KITTITAS COUNTY COMMUNITY DEVELOPMENT SERVICES

RE: Boundary Line Adjustment (BL-25-00020) – Deemed Incomplete – Request for Additional Information

Kittitas County Community Development Services (CDS) received your Boundary Line Adjustment application (BL-25-00020 Martin) on November 6, 2025, for Parcels 20575, and 646233. Staff has reviewed your application and determined that more information is needed before this application can be processed any further. As such, Kittitas County declares your application **incomplete** as of November 20, 2025.

**MARTIN BLA SITE PLAN**  
 TPNS 20575 & 646233  
 805 & 807 E. SANDERS RD.

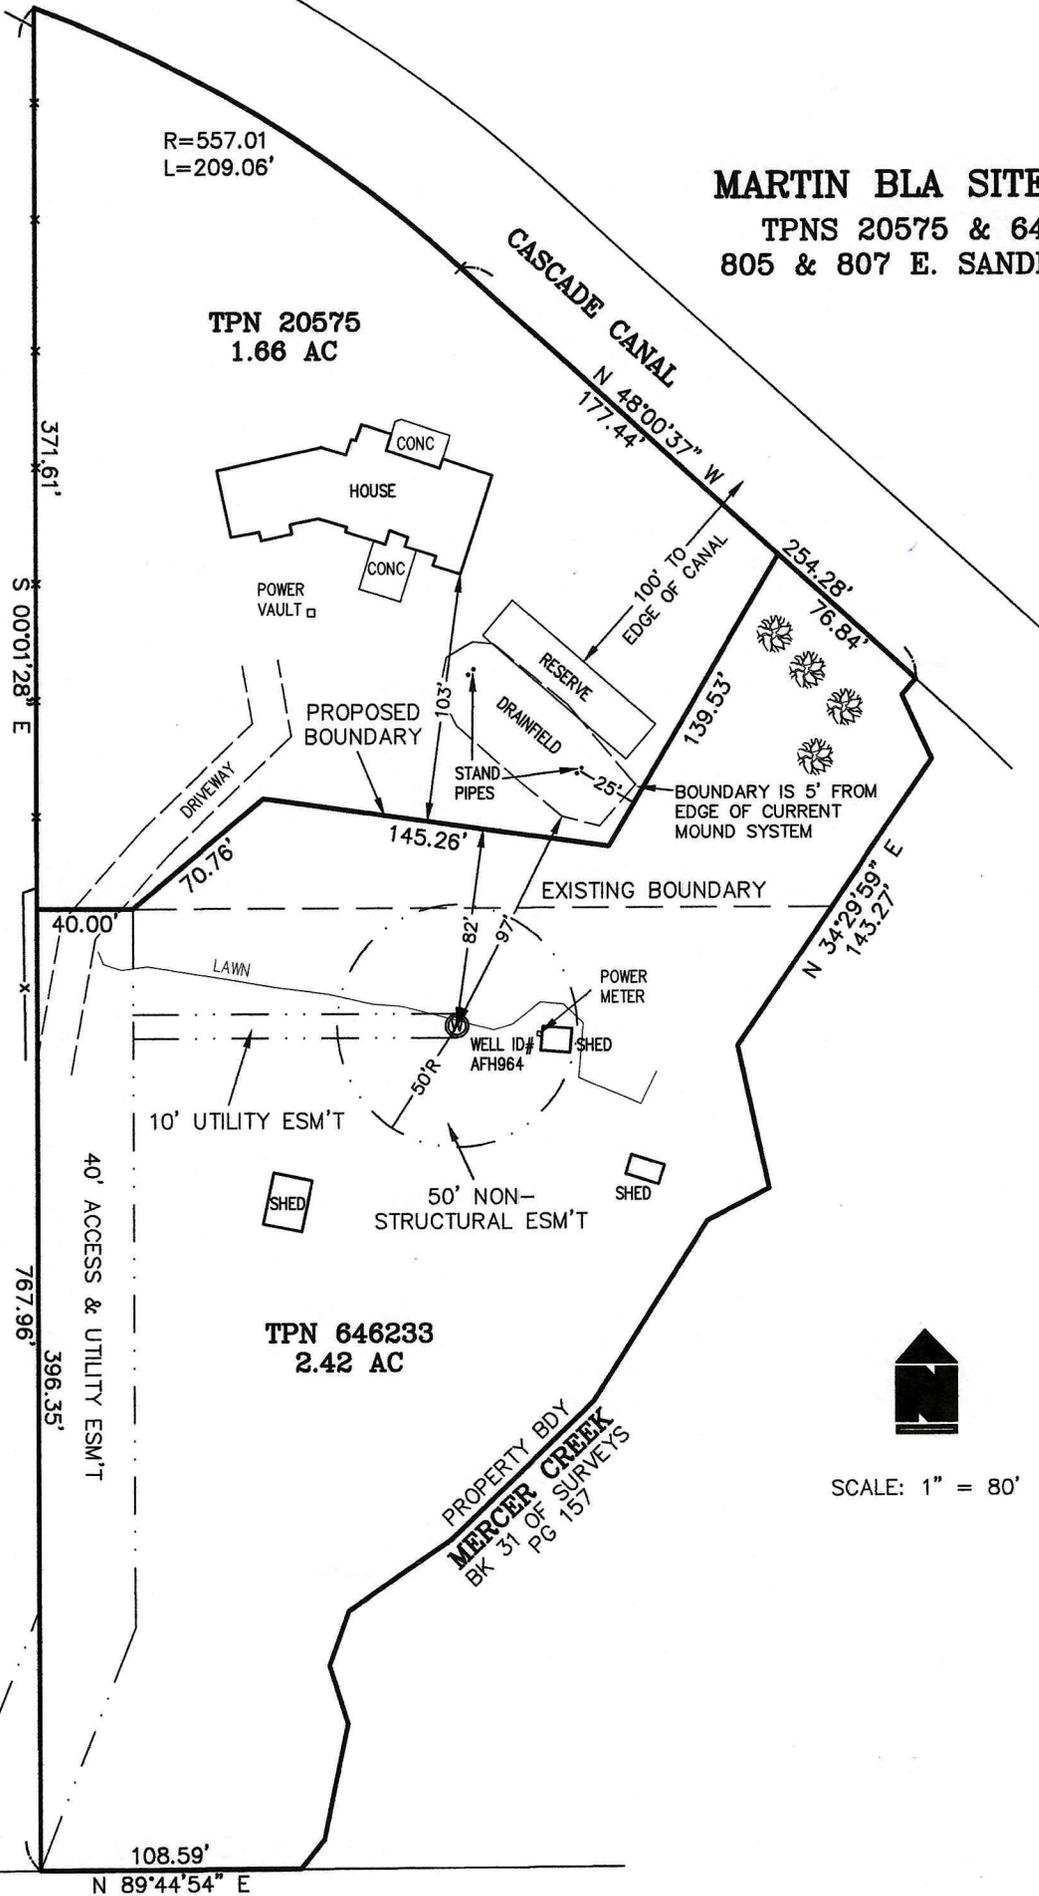
2. On your site plan, all structures that exist on both parcels are required to be labeled. Further, the site plan provided does not show the complete area of both parcels involved in the Boundary Line Adjustment. The septic system components are also not shown to scale.
